Application Ref:		3/2026/0672		 Ribble Valley Borough Council www.ribblevalley.gov.uk
Date Inspected:	N/A	Site Notice:	N/A	
Officer:	LOH			
DELEGATED ITEM FILE REPORT:				APPROVAL

Development Description:	Non-material amendment to application 3/2024/0376 involving the fenestration to orangery to front altered; existing chimney to be removed and replaced with flue pipe.
Site Address/Location:	2 Church Close Clitheroe BB7 2HQ

Client Mr and Mrs Morton		
Project Proposed Extension to 2 Church Close Clitheroe BB7 2HQ		
Drawing Title Proposed Plans and Elevations		
Scale 1:50/100 @ A2	Date April 2024	Drawn LFR
READ DESIGN LTD		
164 - 02 H

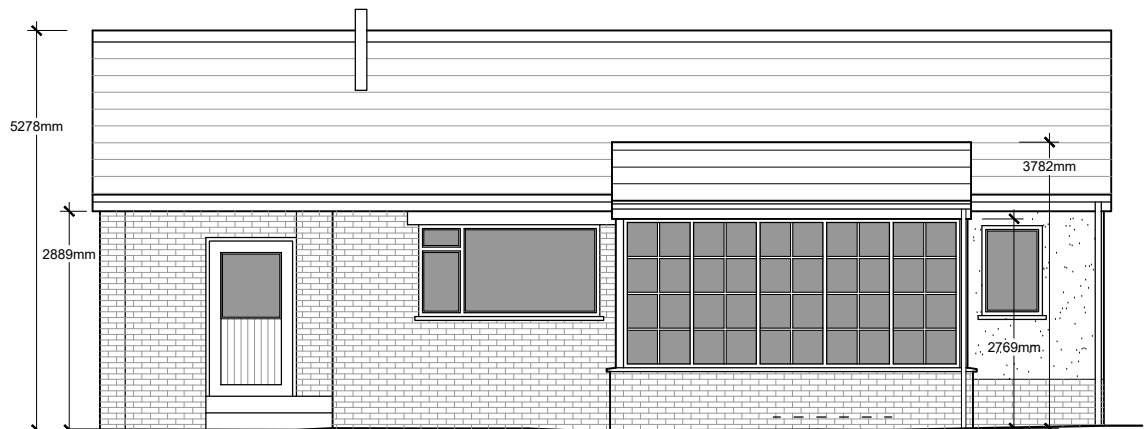
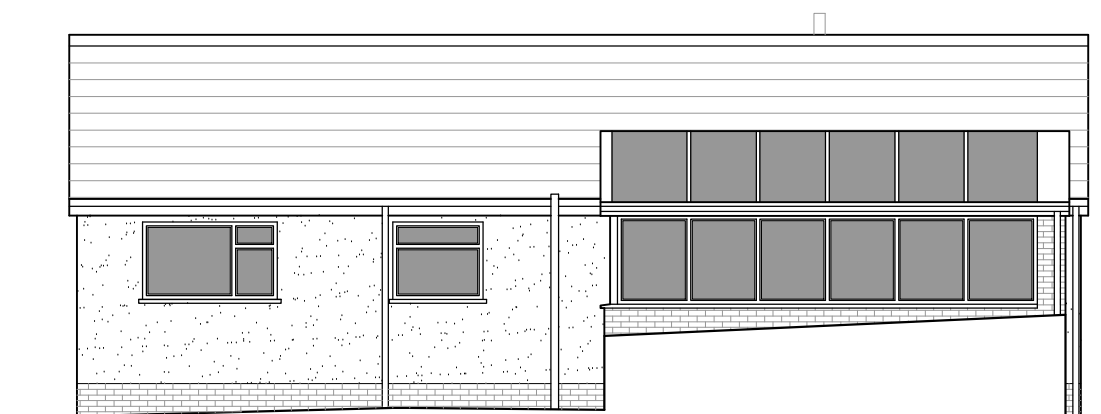
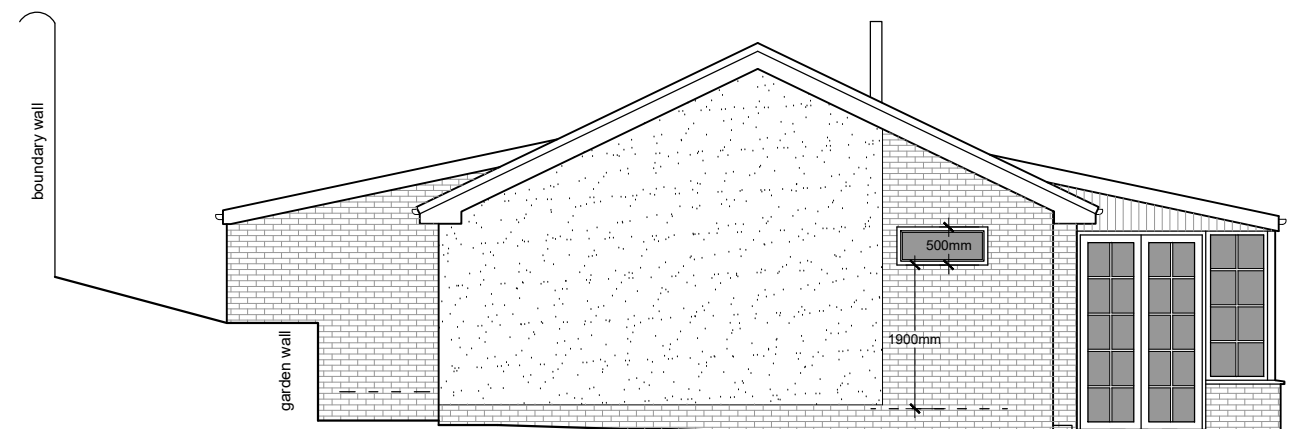
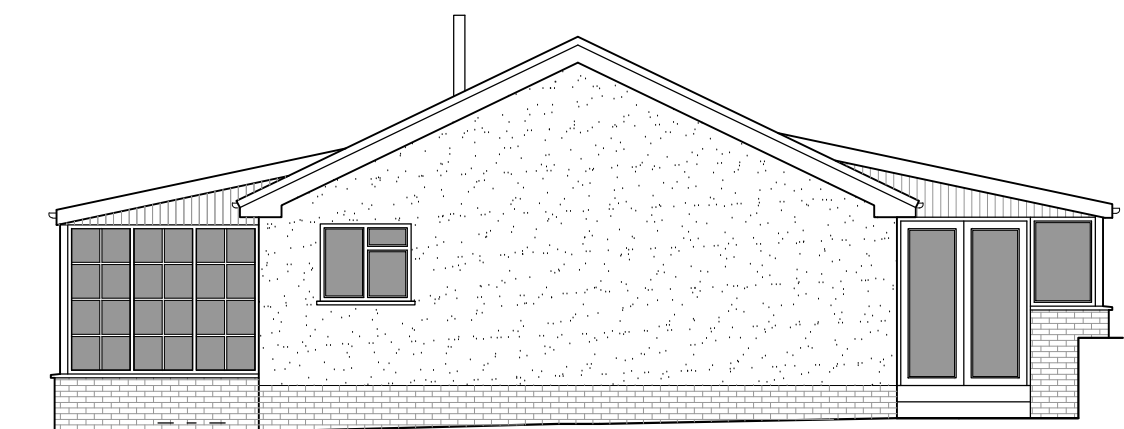
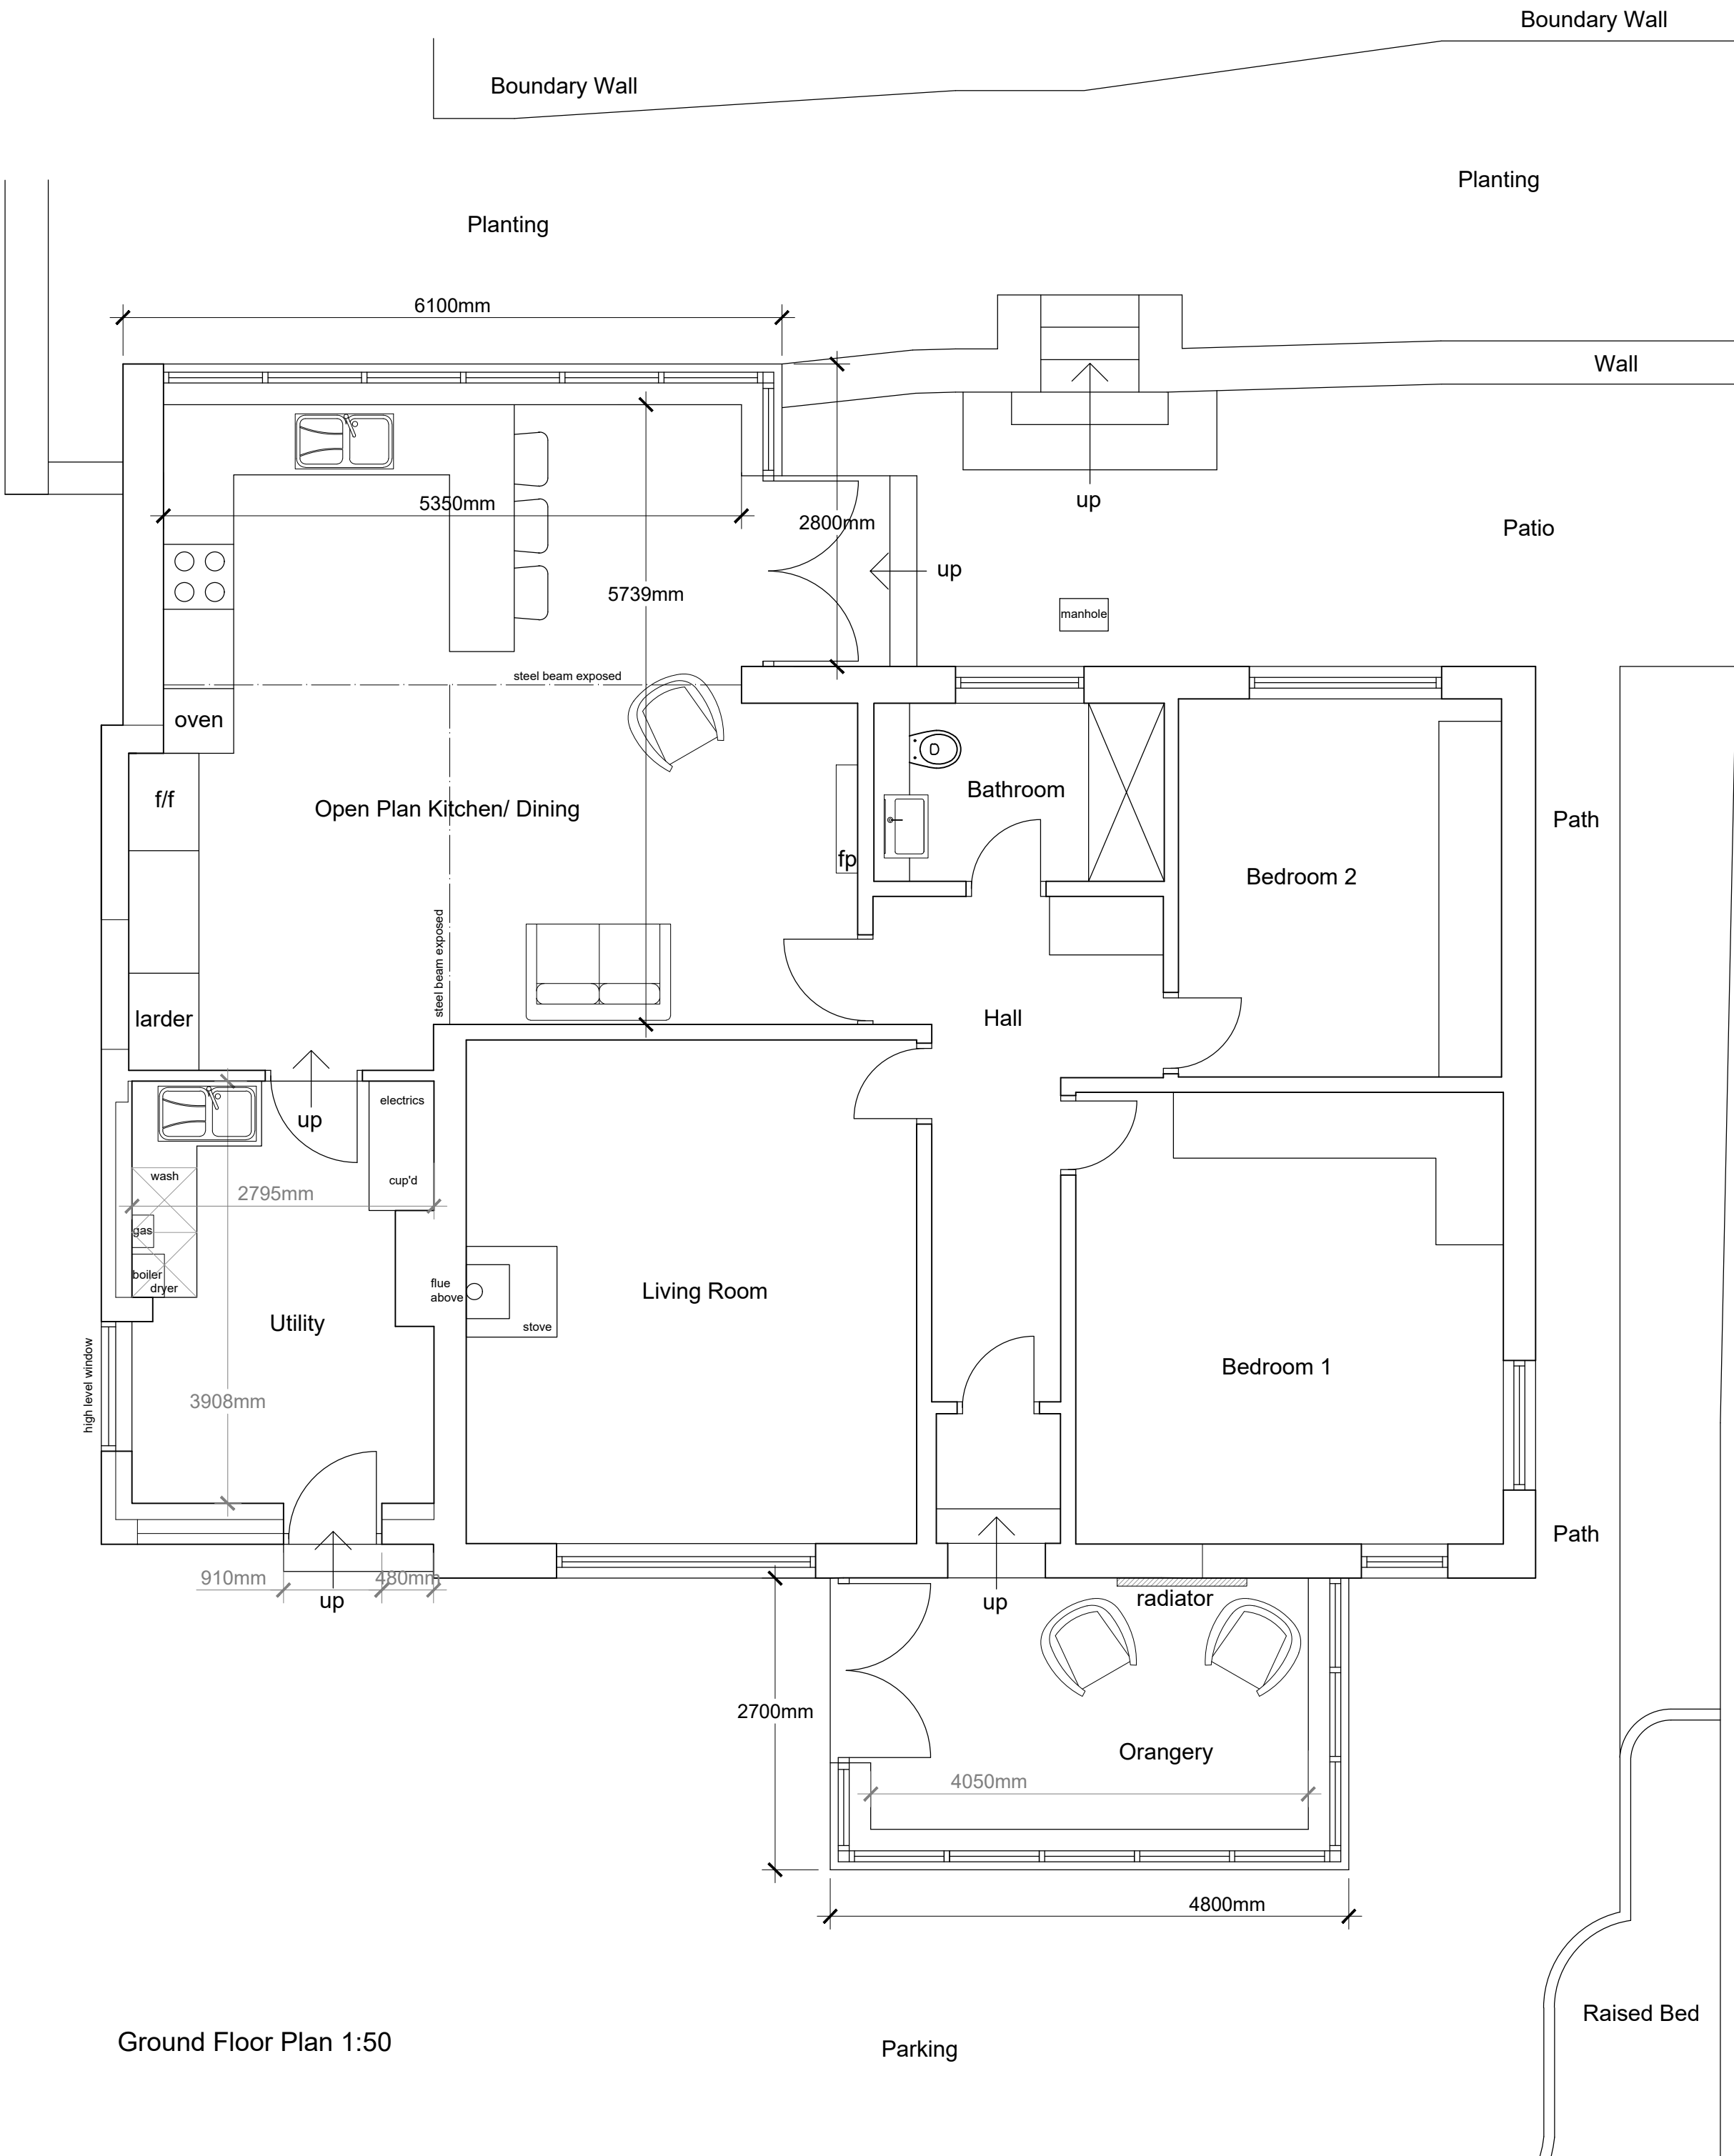
- Reduction in height of the flue pipe by 700mm

The remit of the application relates to fenestration within the orangery altered and the existing chimney to be removed and replaced with a flue pipe. The approved scheme features a largely glazed orangery, with the previously approved rectangular windows to be replaced with rectangular windows each containing 8 fixed square panes. The double glazed door located on the front north west elevation is to be relocated to the side north east elevation. It is proposed that the approved chimney is to be removed and replaced with a flue pipe. The flue pipe is to be of similar height and will be built to comply with relevant building regulations.
